Date: 14 March 2014
Our ref: 113664
Your ref: 14/00042/DISC

**Planning consultation: Partial discharge of condition 16 of TWA/10/APP/01
Location: Oxford To Bicester Rail Link, Buckingham Road, Bicester**

Natural England has reviewed the document for the partial discharge of condition 16 of the above planning permission, which requires a method statement for works which are close to Wendlebury Meads and Mansmoor Closes Site of Special Scientific Interest (SSSI). The measures in the document are broadly satisfactory, however, before the condition can be discharged the following issues need to be addressed:

Figure 2 – Haul roads and storage compound design, Holts Farm

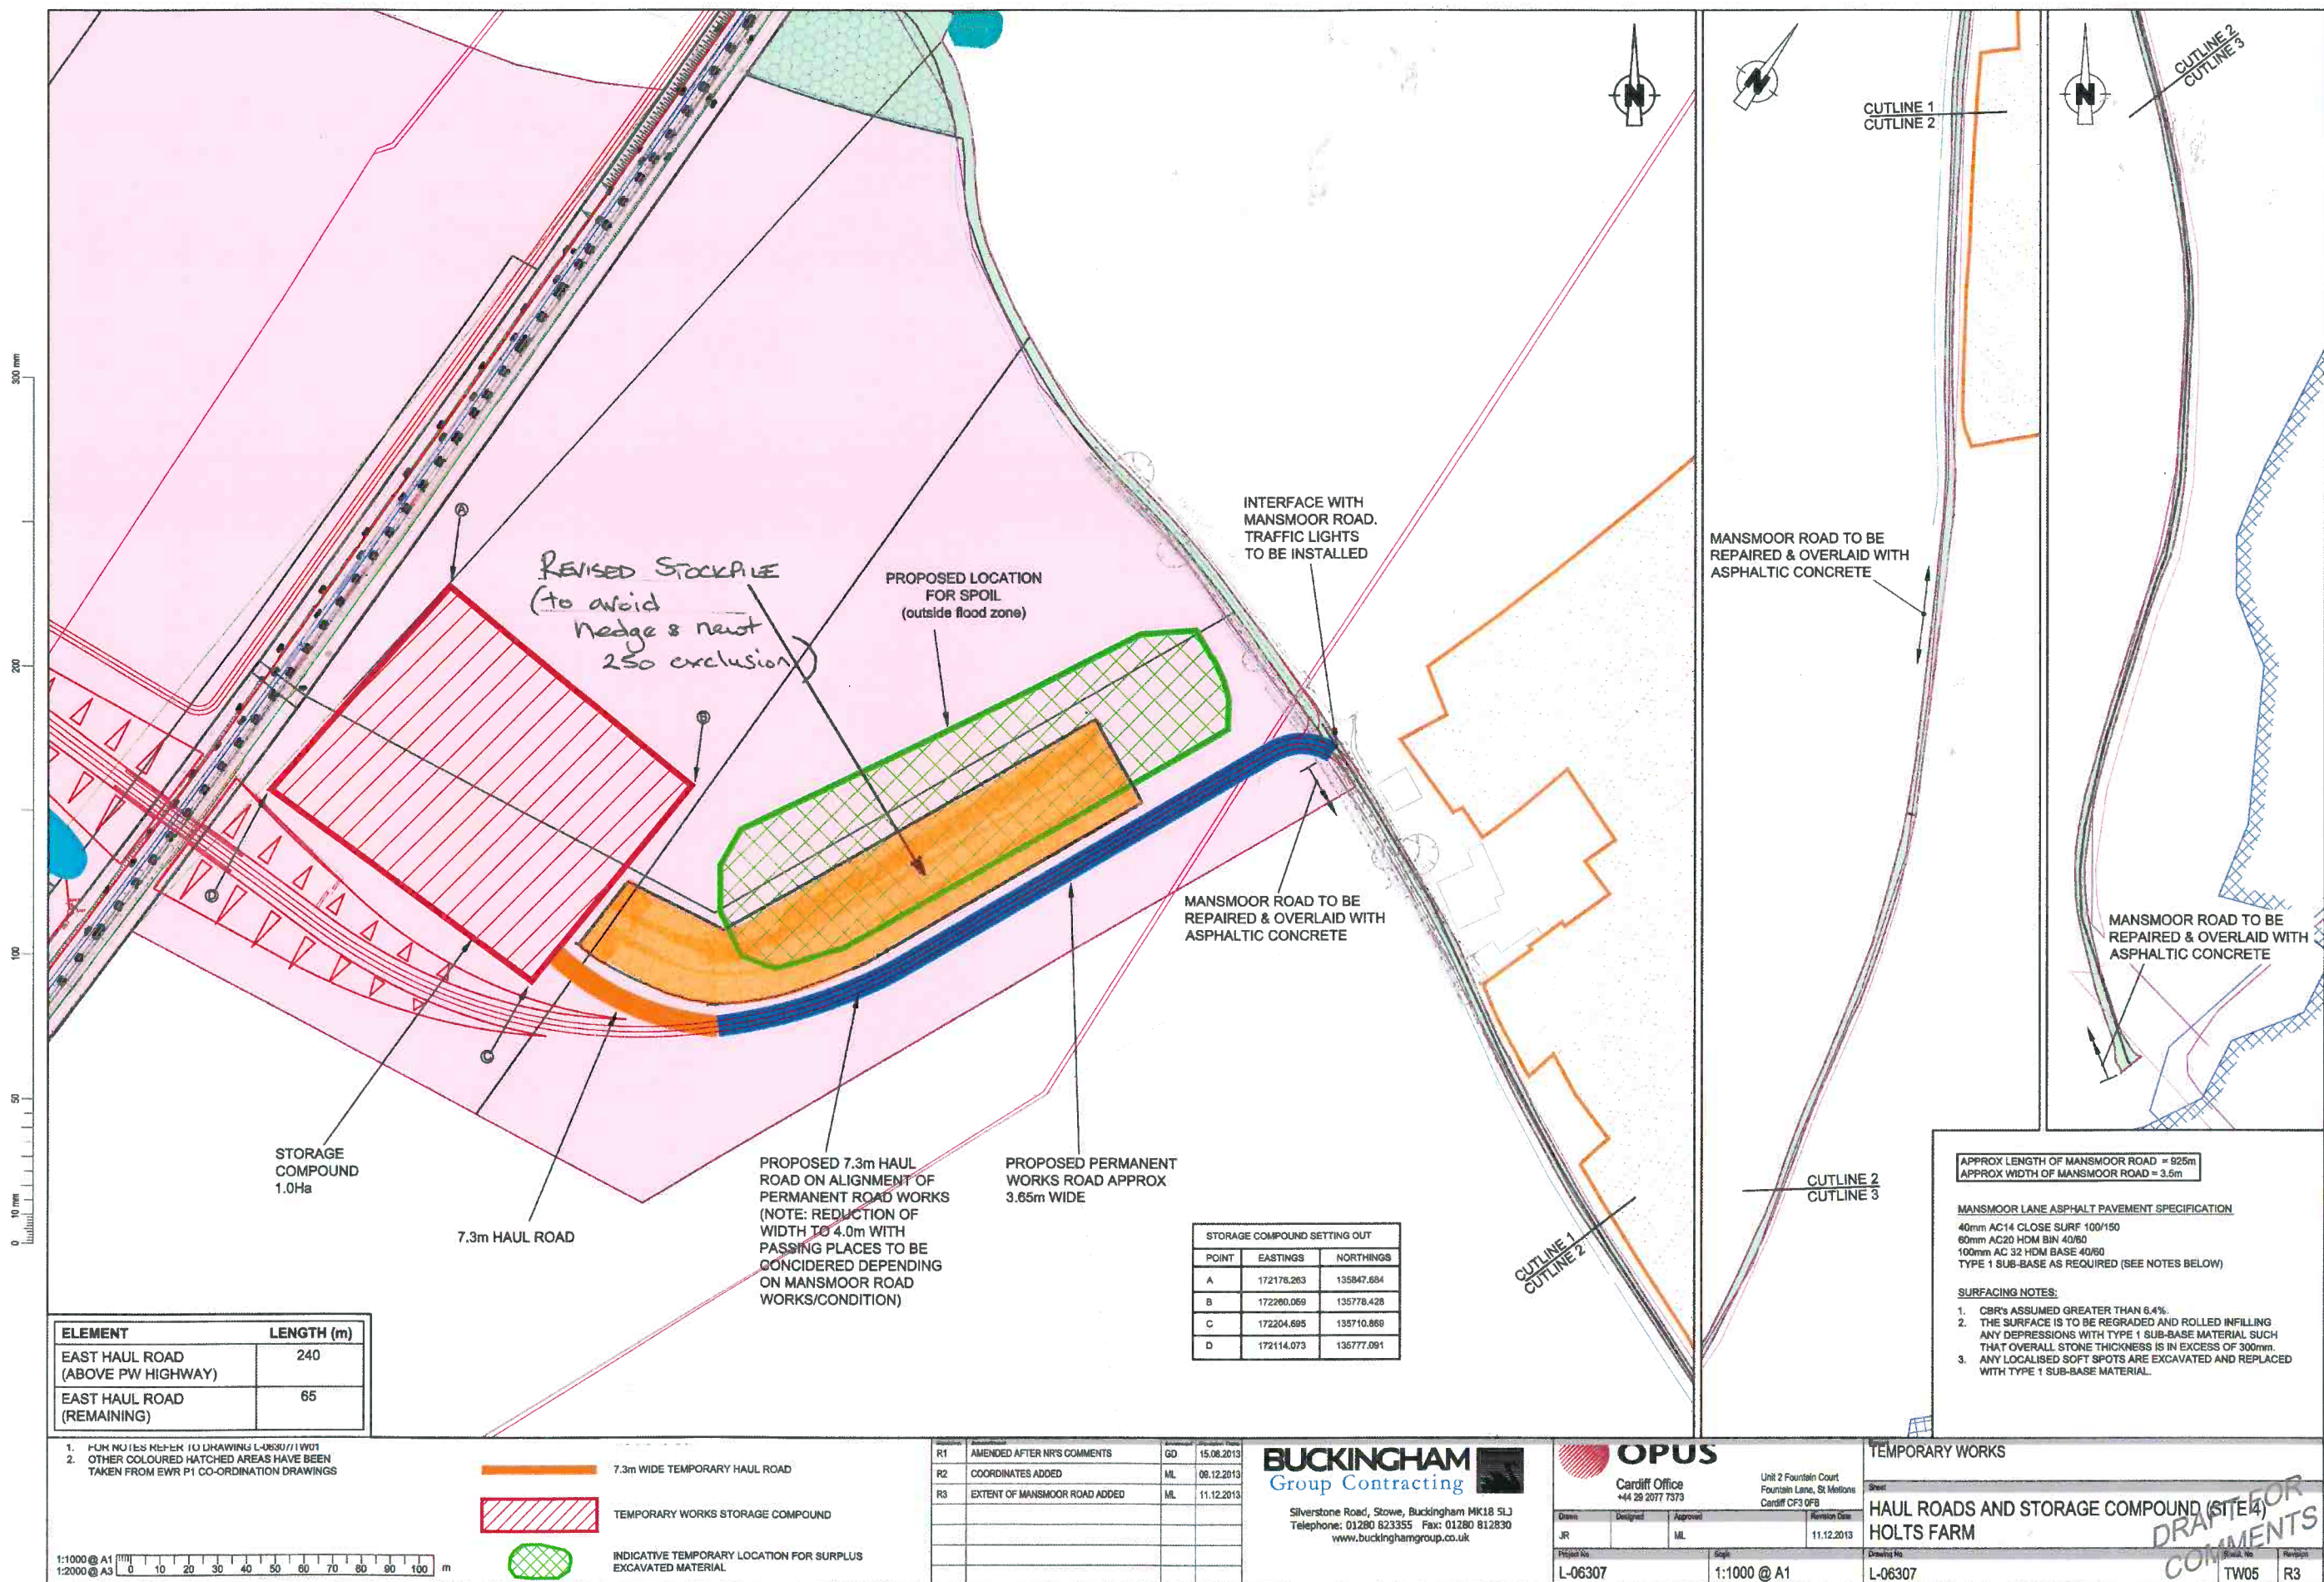
- It is not clear from the document submitted where any new drains planned to flow through the storage area or along the haulage road (or temporary drains that they install) will flow. It is important that any drainage avoids flowing into the SSSI. This needs to be made clear in the document. A drainage map to show where the drains will flow would also be appreciated.
- It is likely that the contractors working on site will encounter snakes. A method statement for this eventuality needs to be added to the section on protected species.
